From: Gabrielle Helyer [REDACTED]
Sent: 08 July 2021 14:33
To: Jasmine Kaur Singh [REDACTED]
Cc: emma [REDACTED]
Subject: Fwd: LU/134/21/PL & LU/135/21/L The Farm, East Street, Littlehampton

From: emma [REDACTED]
Sent: Friday, June 25, 2021 4:30 pm
To: Jasmine Kaur Singh
Cc: Martyn White; [REDACTED]; Gabrielle Helyer; [REDACTED]
Subject: Re: LU/134/21/PL & LU/135/21/L The Farm, East Street, Littlehampton

From: emma [REDACTED]
Sent: 07 May 2021 16:06
To: Jasmine Kaur Singh [REDACTED]
Cc: Planning.Response [REDACTED]
Gabrielle Helyer <[REDACTED]> Martyn White
[REDACTED]
Subject: LU/134/21/PL & LU/135/21/L The Farm, East Street, Littlehampton

Drawing Name
Location and Block Plan

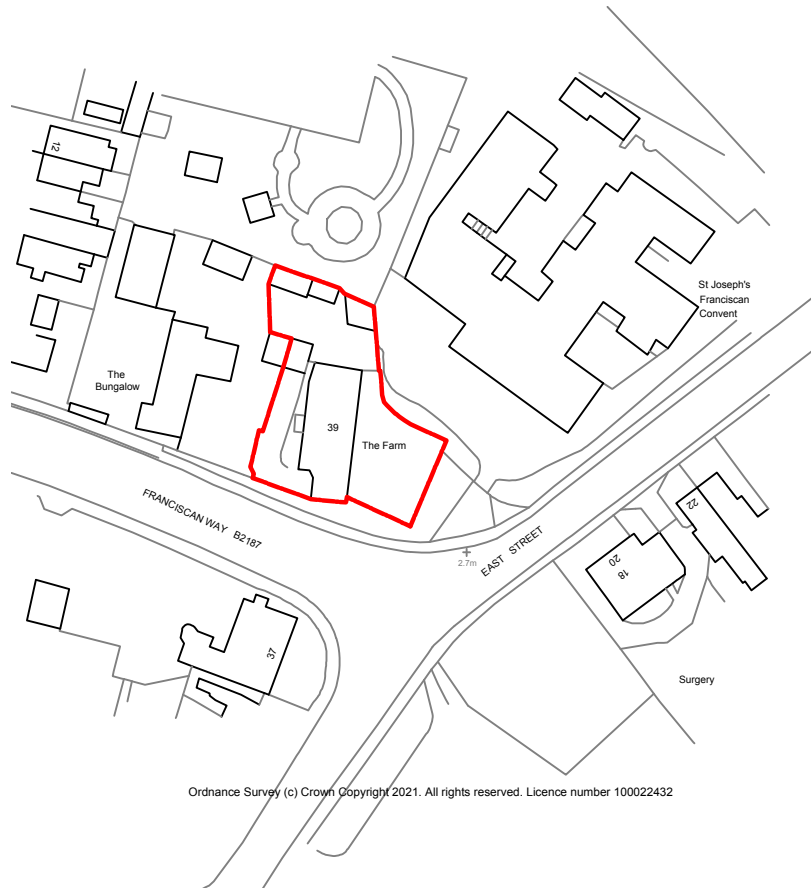
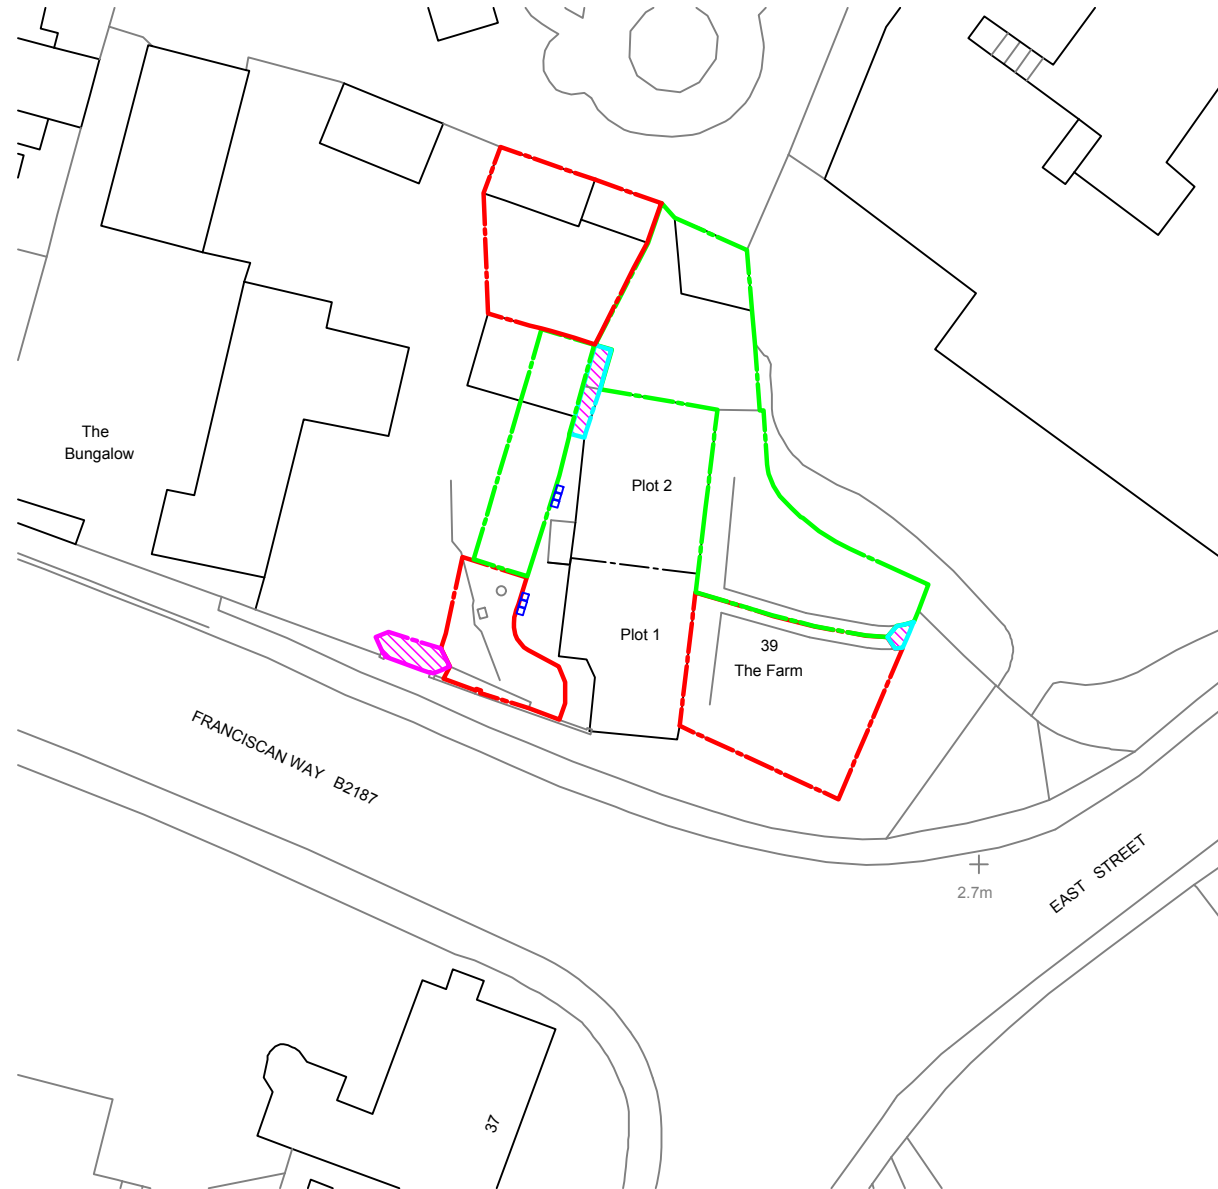
Also if you could confirm about the parking facilities on site ?

Please find attached a document which I trust addresses your query over the proposed parking arrangements.
